Filename: QQ-181210CSCOBAFR2

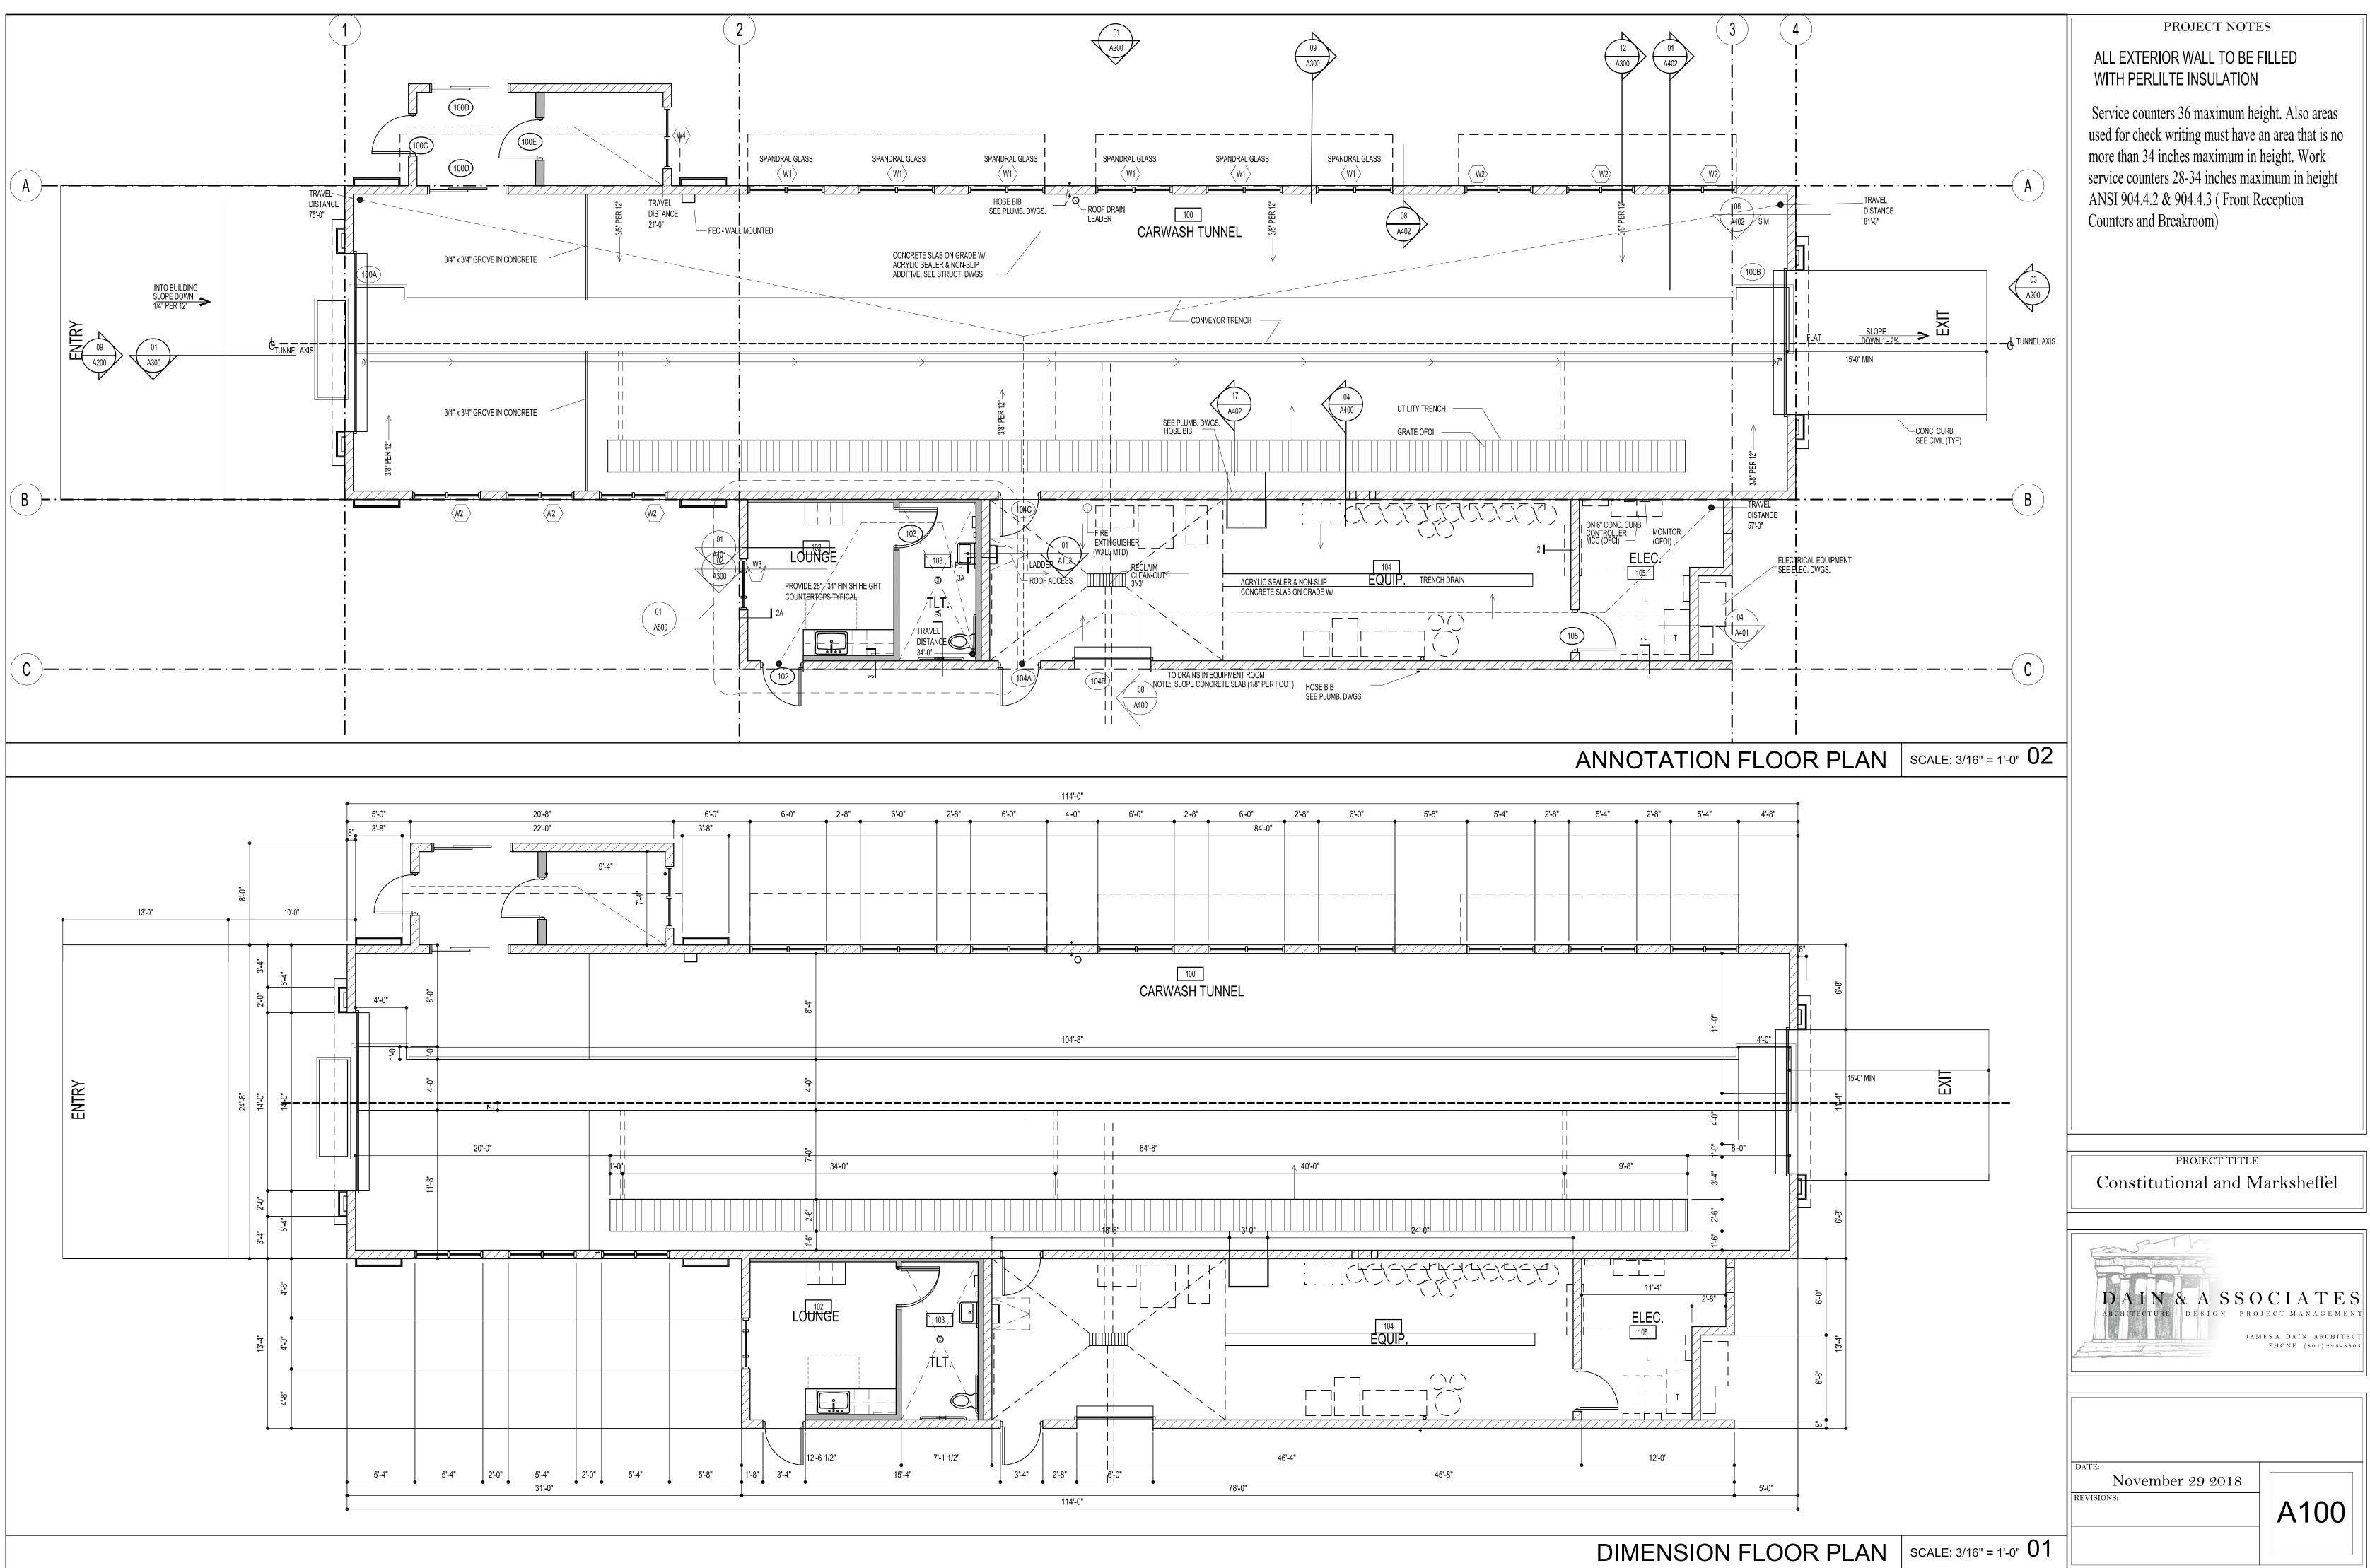
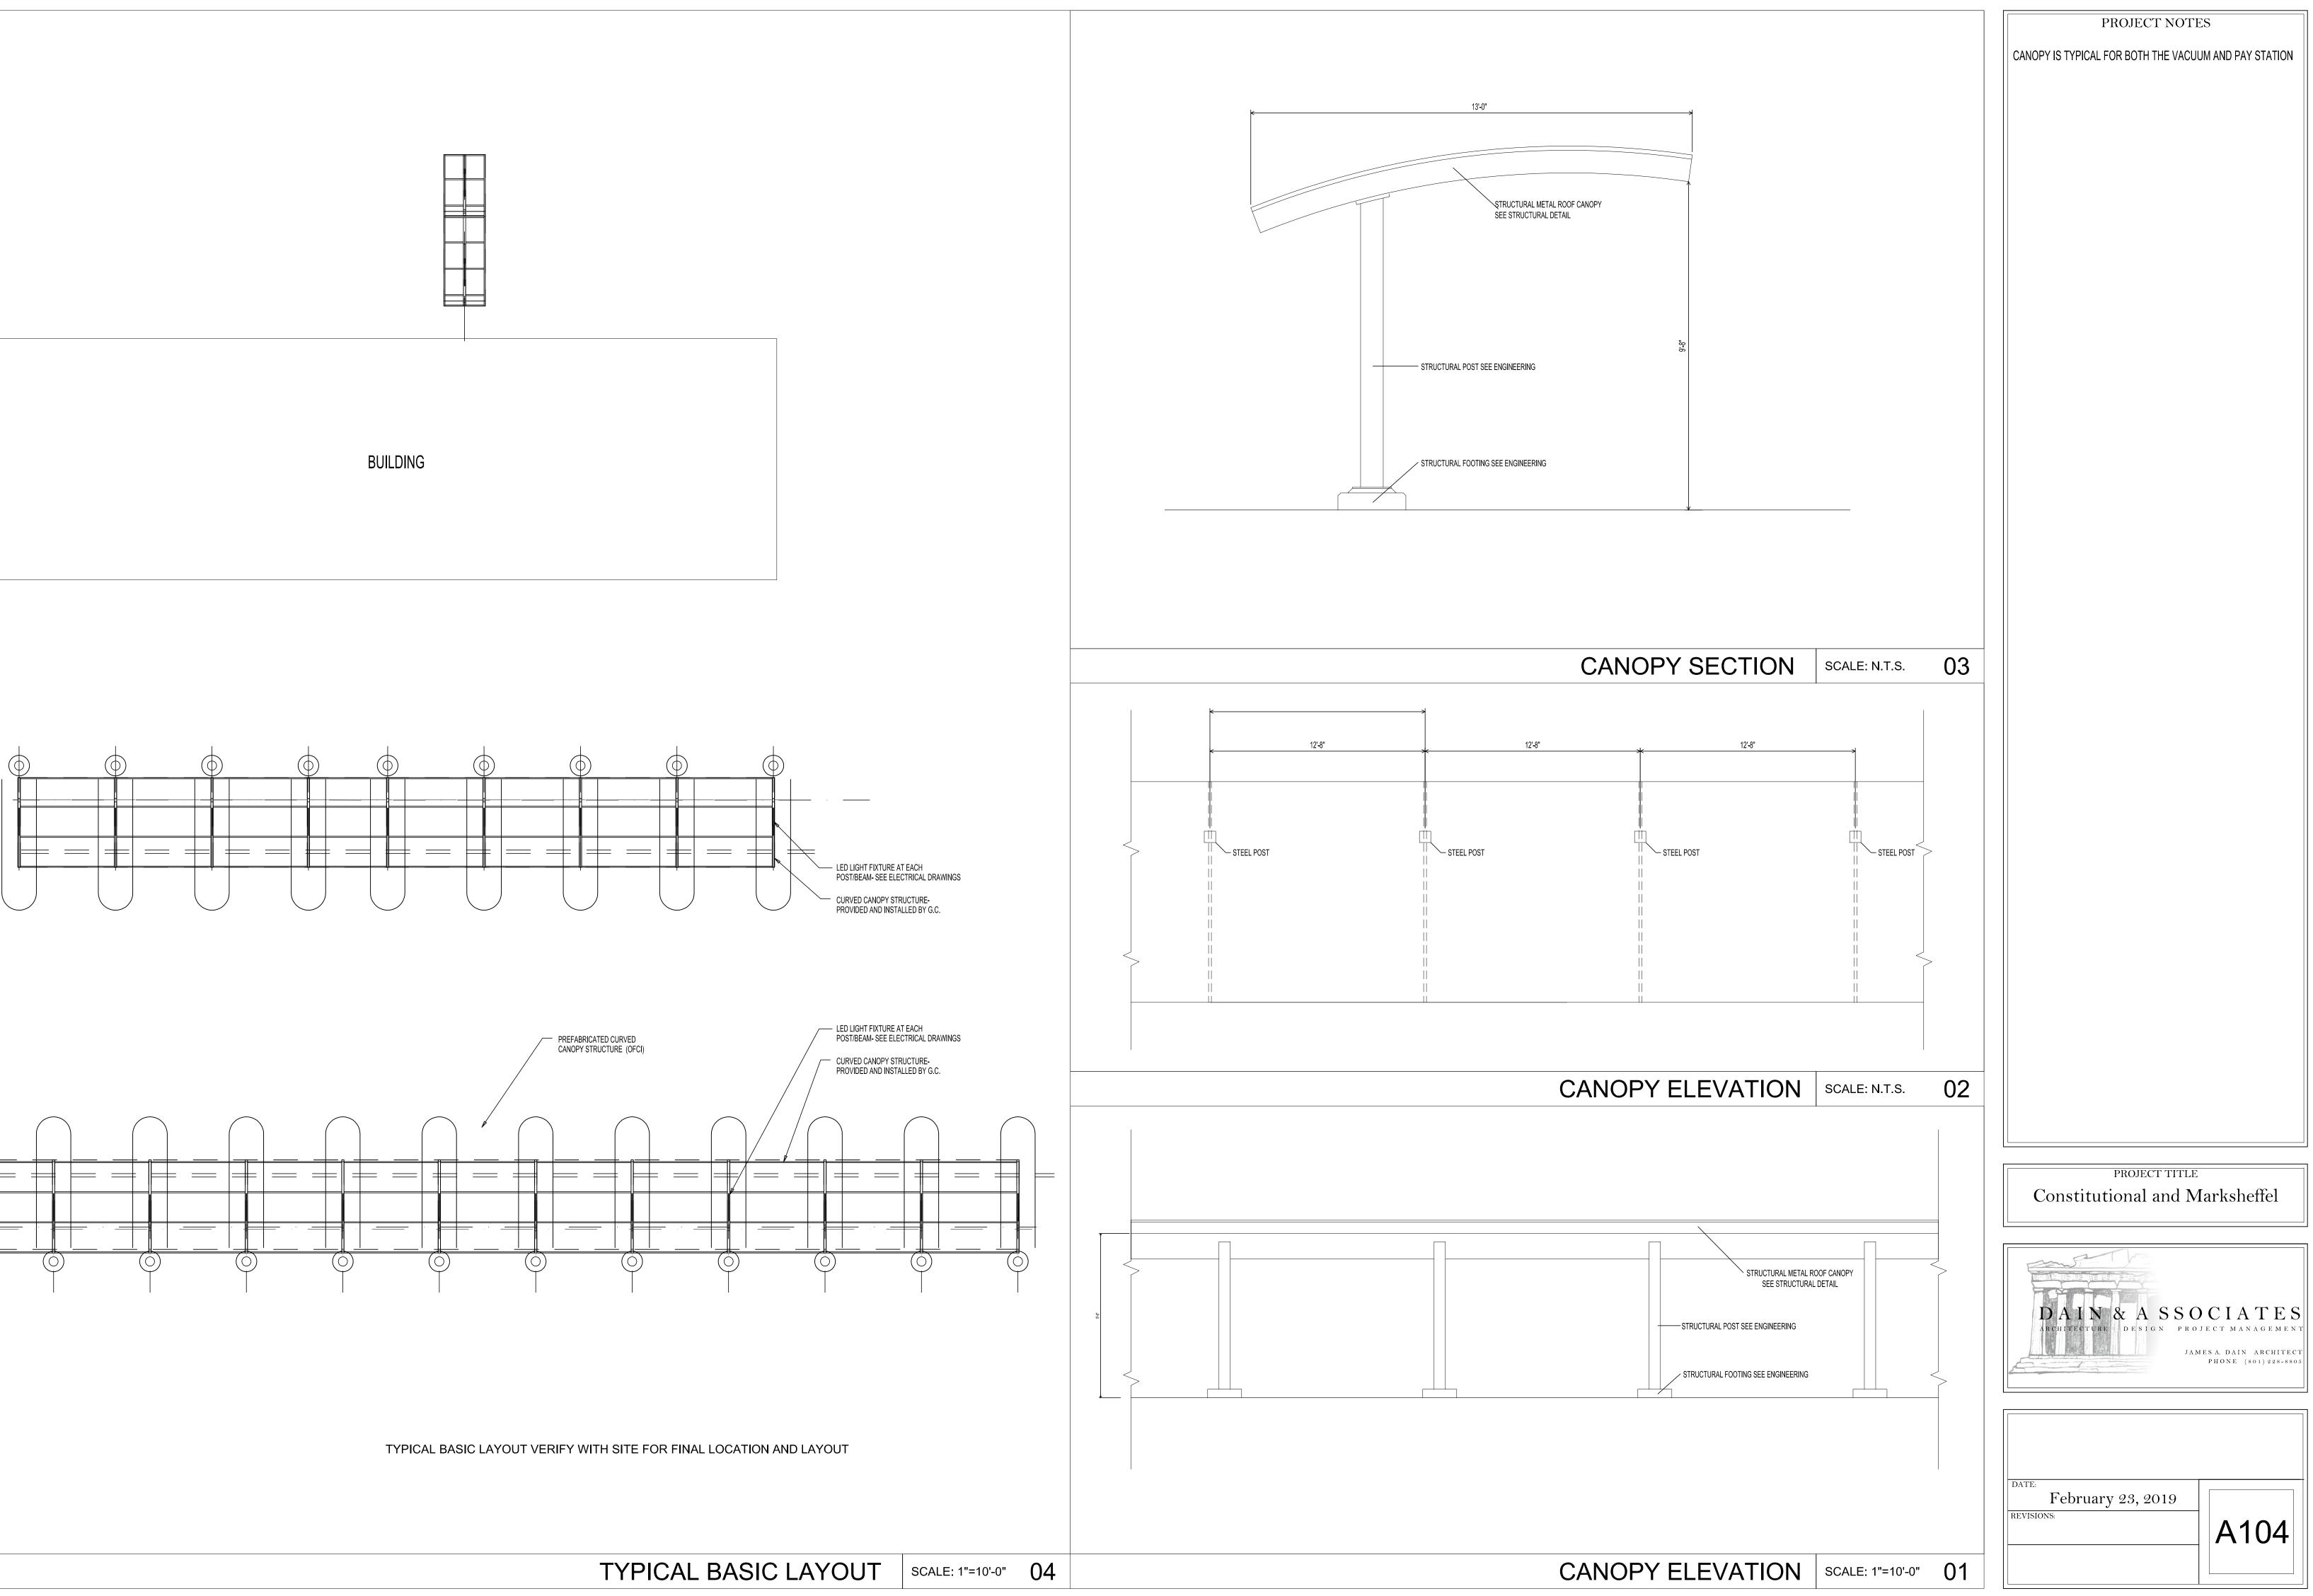
Section 6.2.3(B)(1)(d)
Maximum Levels, on-site lighting shall not exceed 10 footcandles throughout the site.

Layout subject to change based on no vacuum stalls allowed in water easement

1' Shield/Baffle 6" away from the fixture to achieve the spill goal.
